COUNTY COUNCIL'S RESPONSE TO CONSULTATION ON THE FOLLOWING DEVELOPMENT PROPOSAL

Application No: 18/02169/F

Proposal: Temporary change of use of the eastern part of southern taxi way for use in connection with established and lawful car processing operations.

Location: Heyford Park, Camp Road, Upper Heyford, Bicester OX25 5HD.

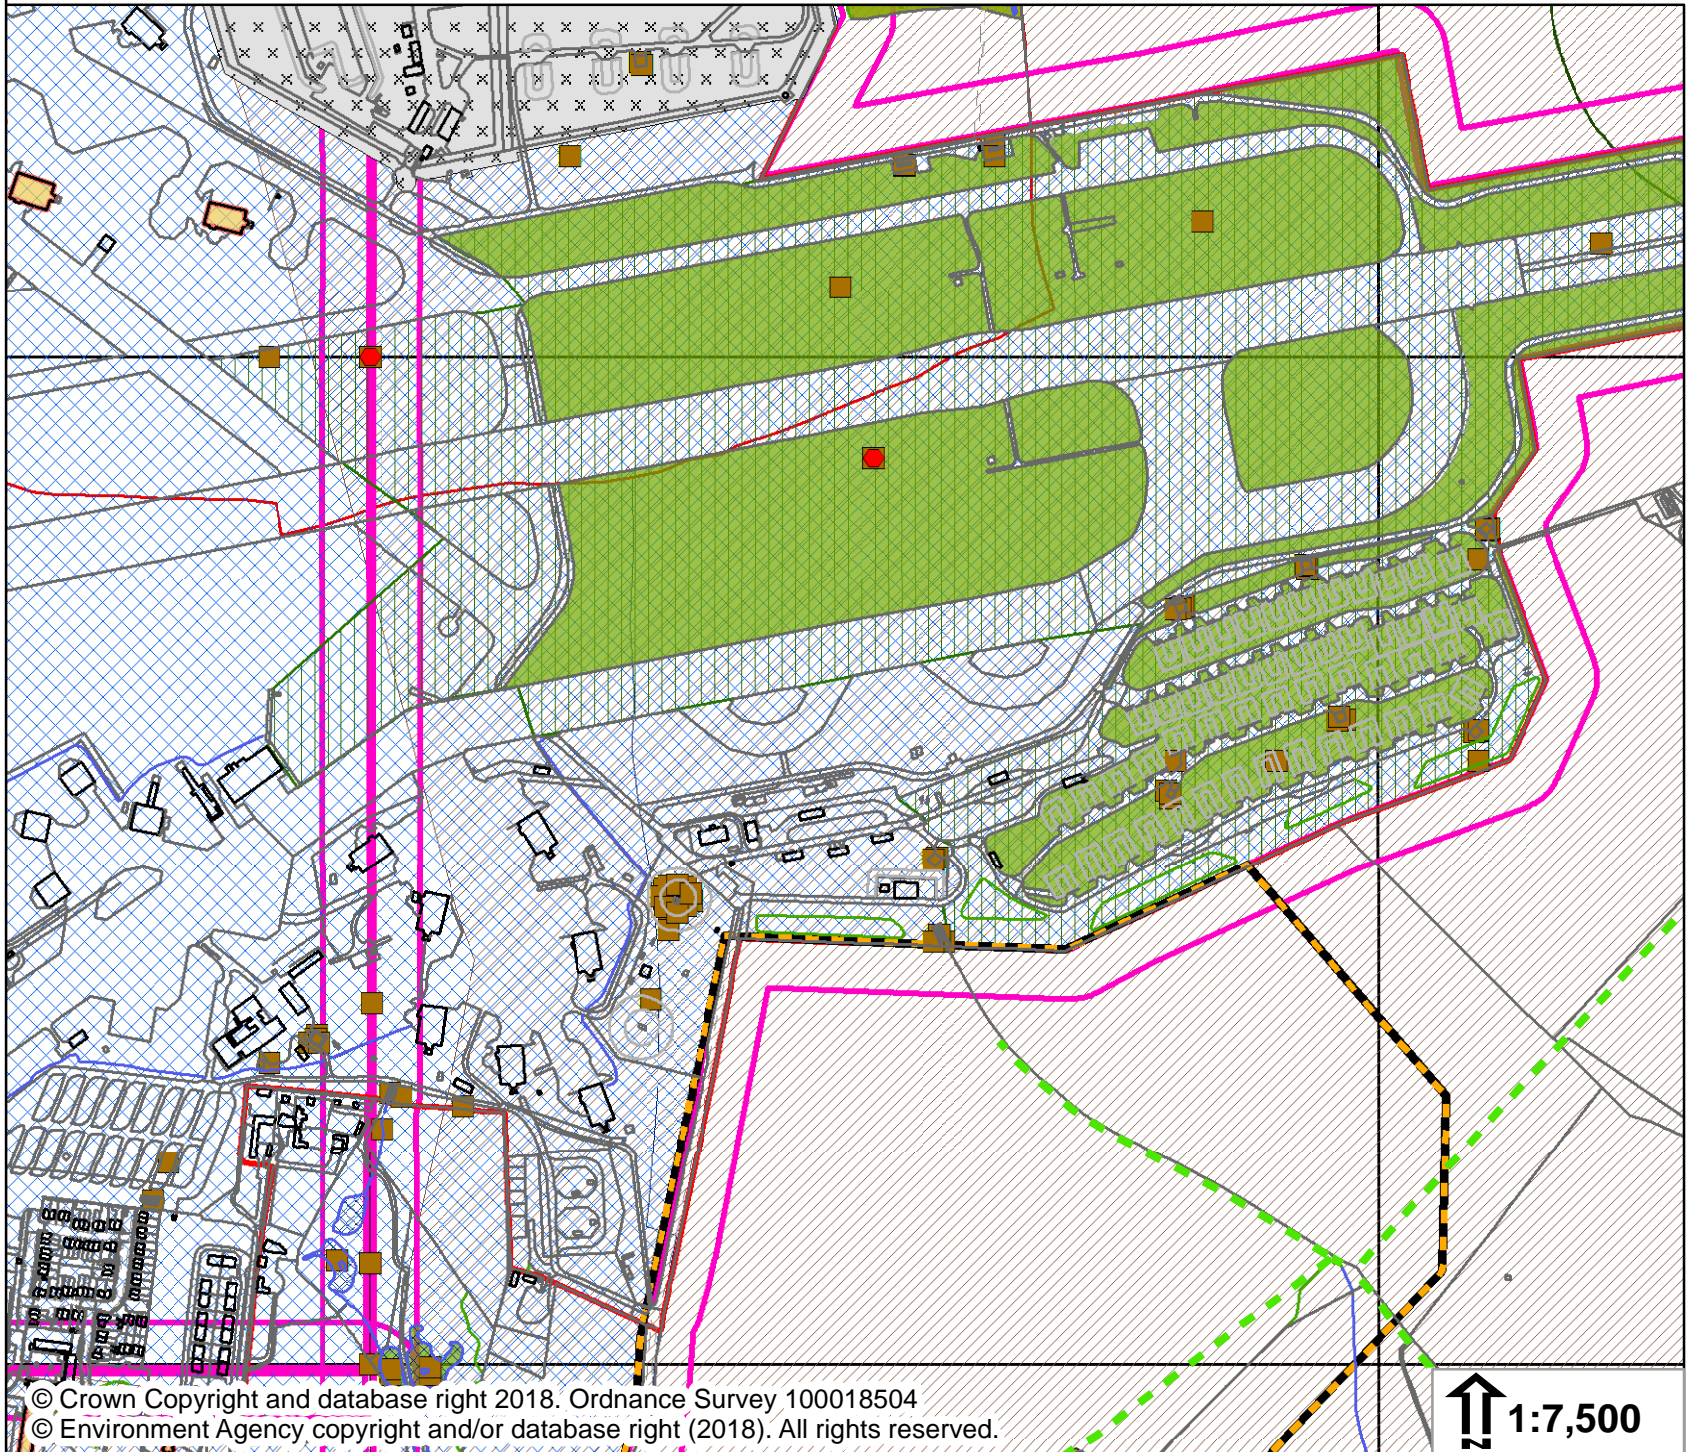
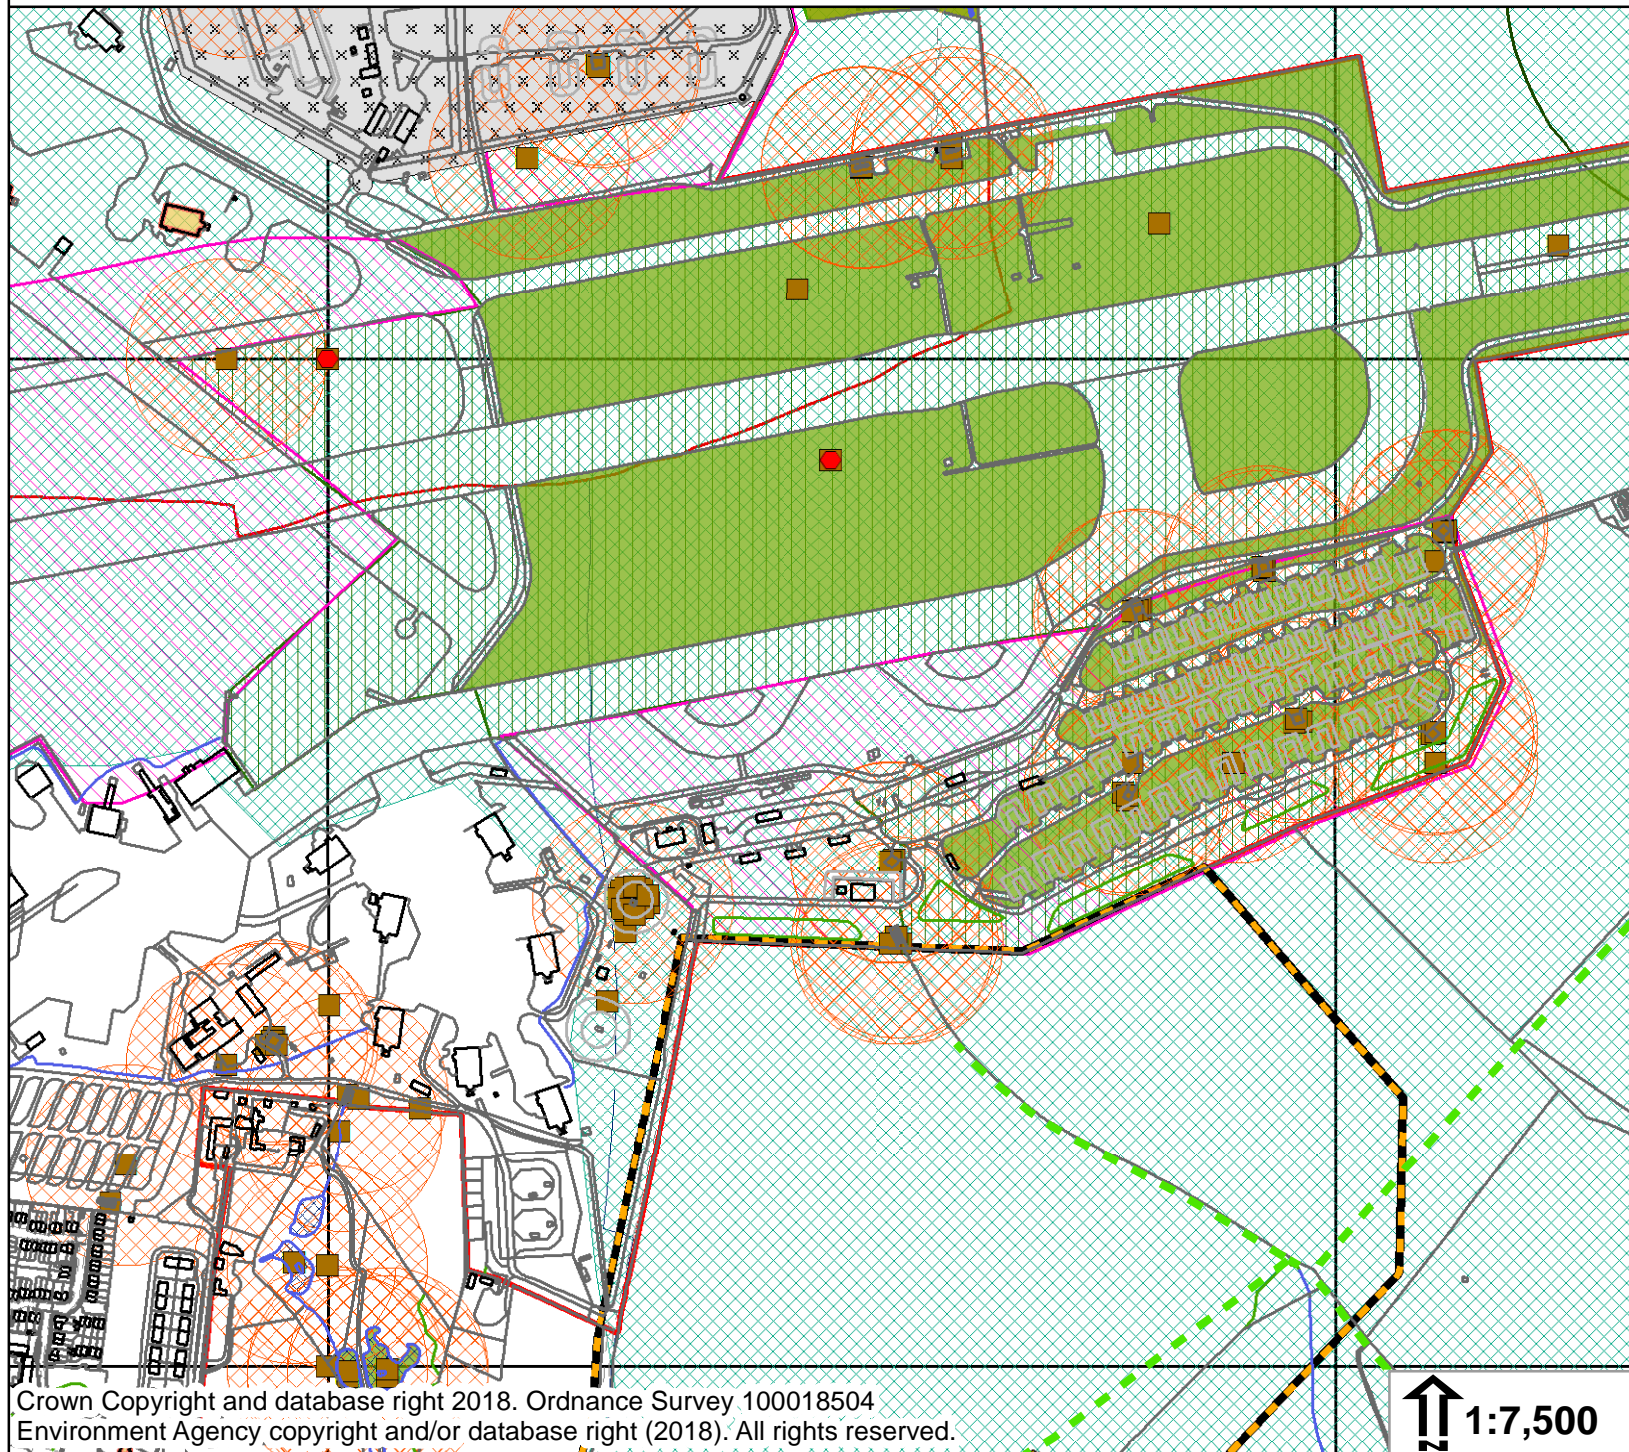
This proposal could prevent the reopening of Aves Ditch on something approaching its historical line as set out in the sketch below. The possibility of this is included in the County's response to the hybrid application, as it links to the ecological and explosives constraints for the proposed route south of the bomb store. At this stage the need for this cannot be discounted as Aves Ditch has not yet been reopened and so this development could prejudice this provision. **Reason for objection.**

AREAS PLAN

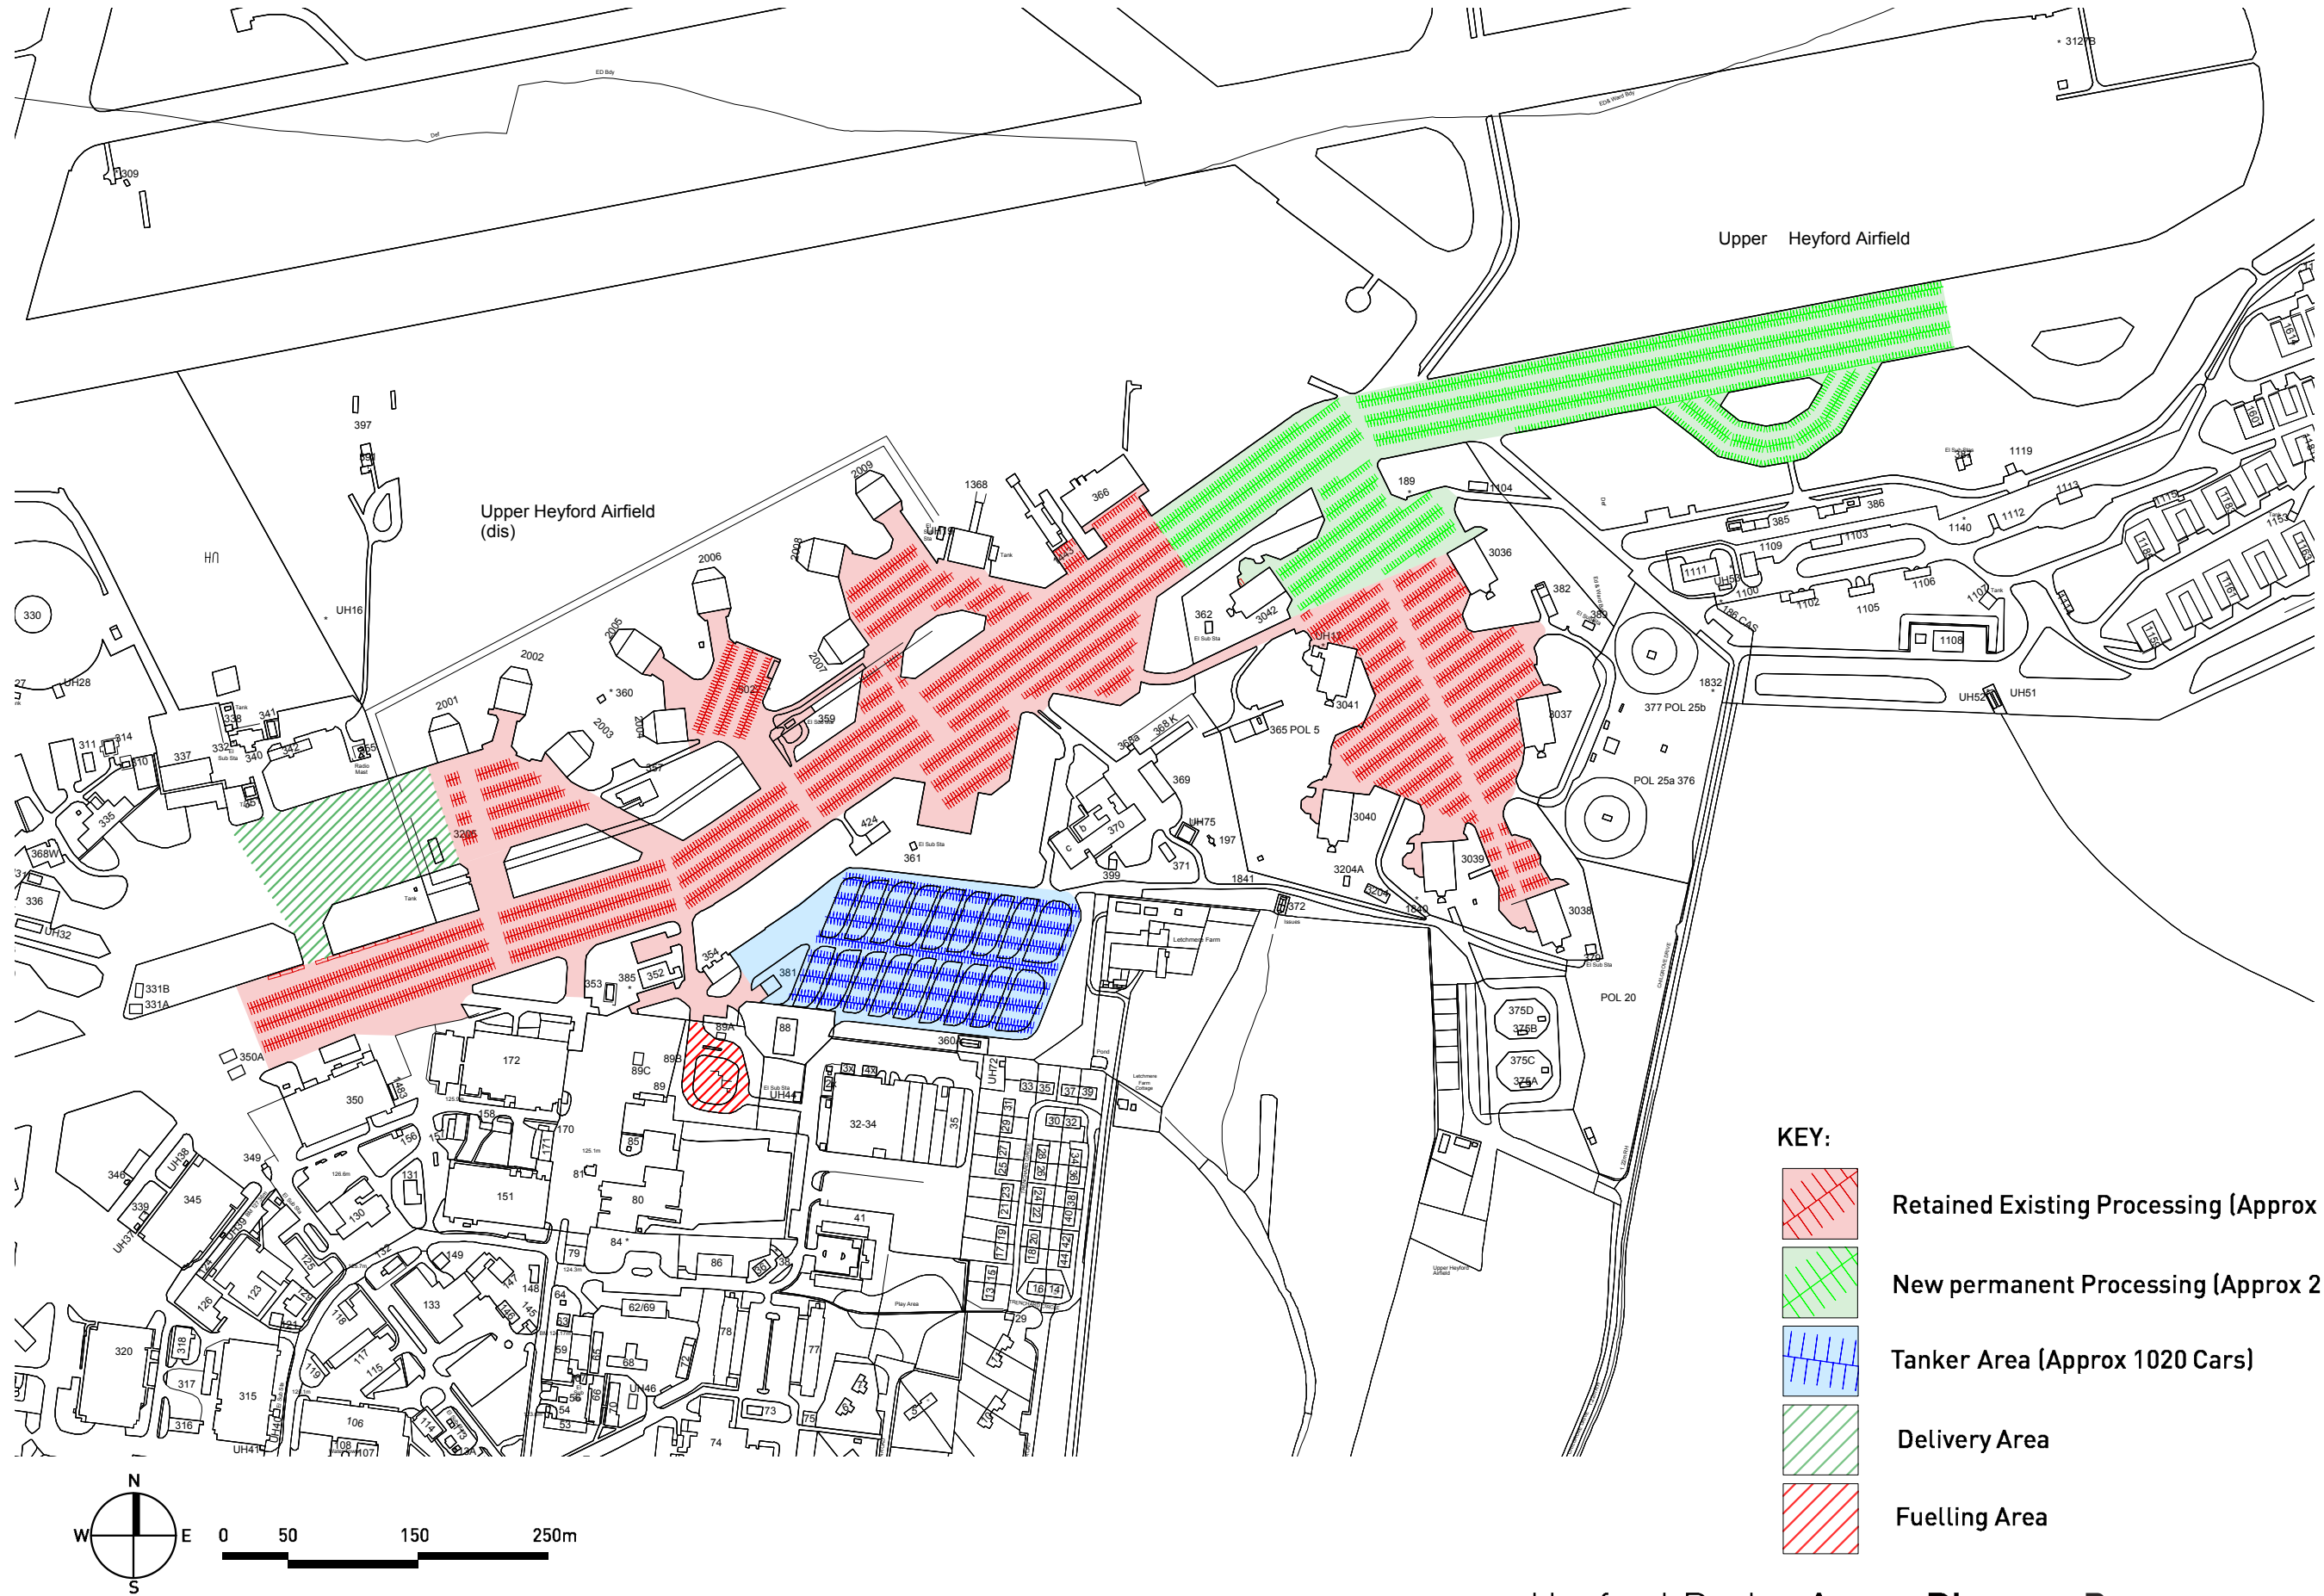
The Planning and Heritage Statement states that: *“The proposals seek planning permission for the continued and extended use of the eastern part of the southern taxiway...”*. However, the application documents do not seem to demonstrate the geographical extent of this extended use. In this connection it appears from the Planning and Heritage Statement that there will be an increase in car processing capacity from the currently permitted 6,000 vehicles per annum to 8,000 vehicles per annum. Associated with this, the application form reveals that there will be an increase of 849 car parking spaces from the current 7,020 to a proposed 7,869.
